State of Washington
DEPARTMENT OF FISH AND WILDLIFE
South Central Region • Ellensburg District Office
1130 W. University Way, Ellensburg, WA 98926

October 1, 2018

RE: WDFW comments on SD-18-00001 Williams Shoreline Substantial Development along Manastash Creek

DRIVEWAY AND BRIDGE SITE PLAN  
DRAWING 10

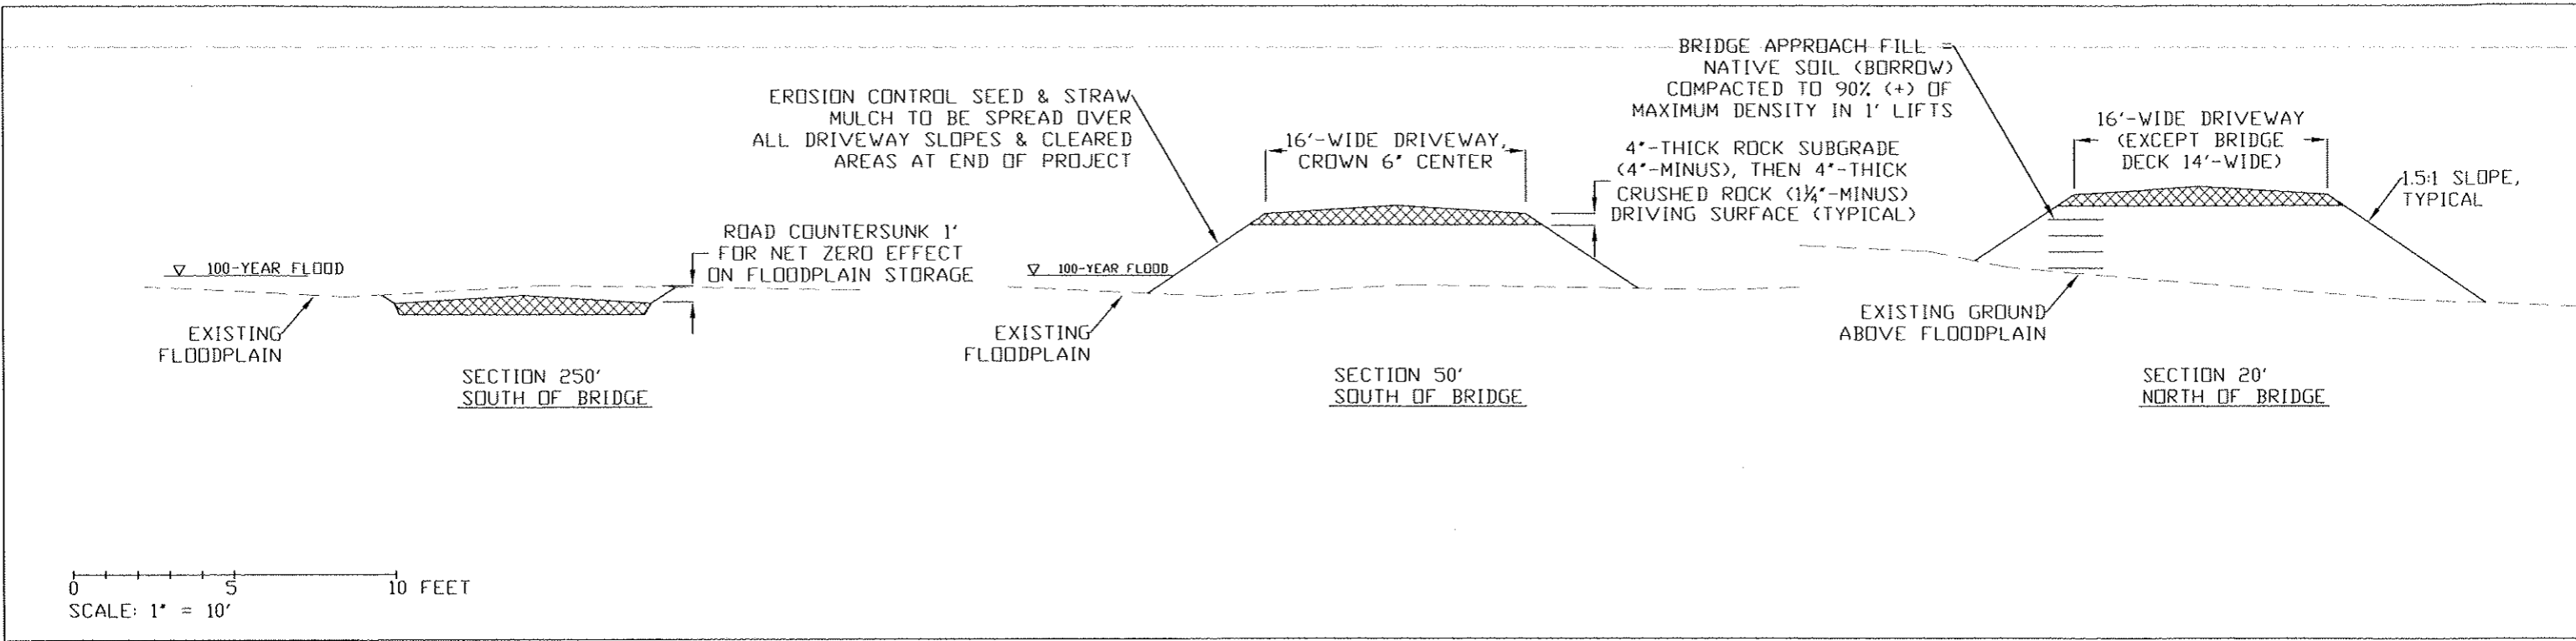
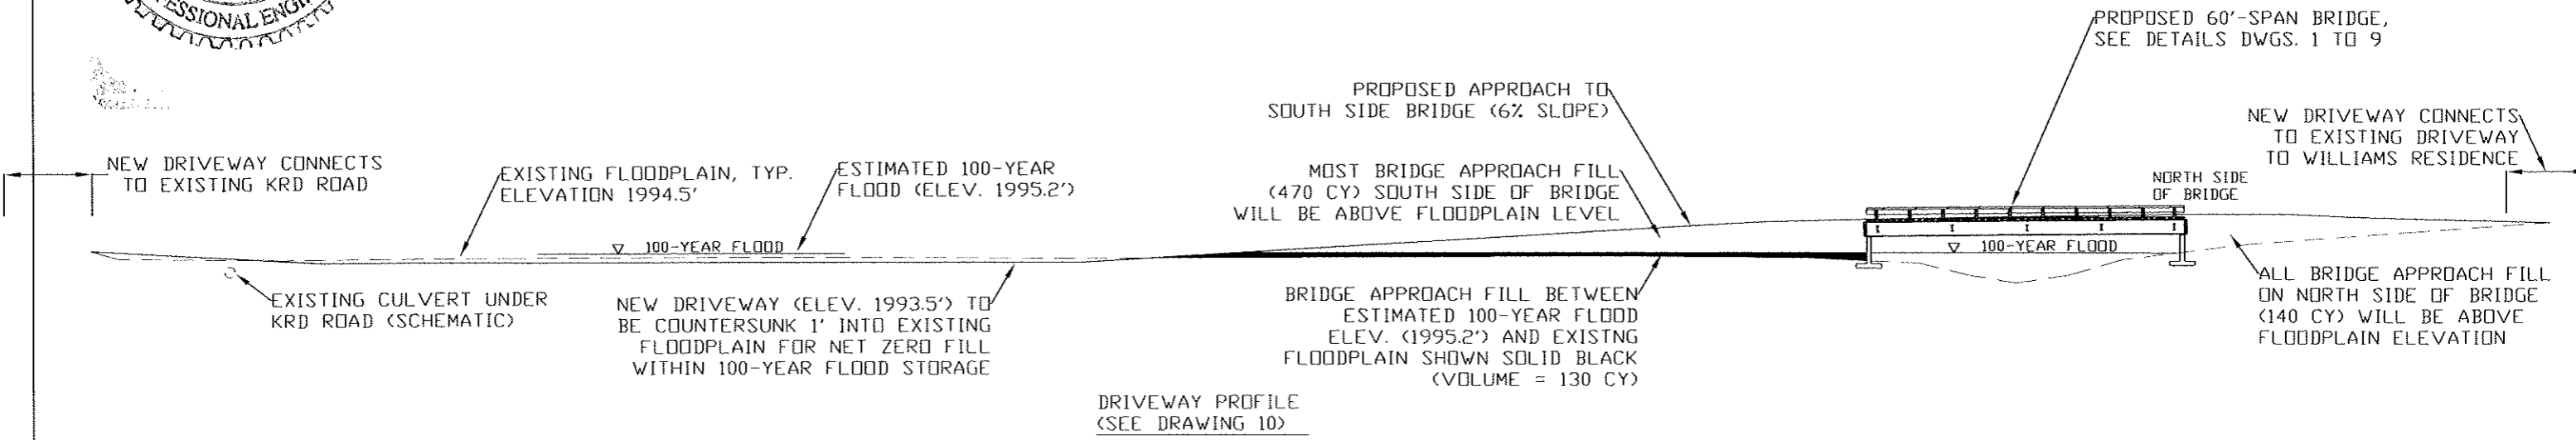
While the application materials may be sufficient for hydraulic project review, they lack information needed for the Shoreline Development Permit review. The application materials do not reflect the clearing or fill (grading) needed for driveway construction through the vegetated riparian habitat and Shoreline designated as Rural Conservancy. In the SEPA checklist, the area of disturbance and impervious surface only describes the footprint of the bridge deck (14' x 60') and does not describe actions within the Shoreline jurisdiction that will occur to construct the driveway on either side of the proposed bridge. Without this information, it is difficult to assess impacts to the Shoreline environment, critical areas, or the 100 year floodplain. The riparian corridor along Manastash Creek provides habitat for fish and wildlife and it helps to stabilize the

Please provide additional information for the design and construction of the driveway associated with the proposed bridge and any other work that is proposed within the Shoreline jurisdiction.
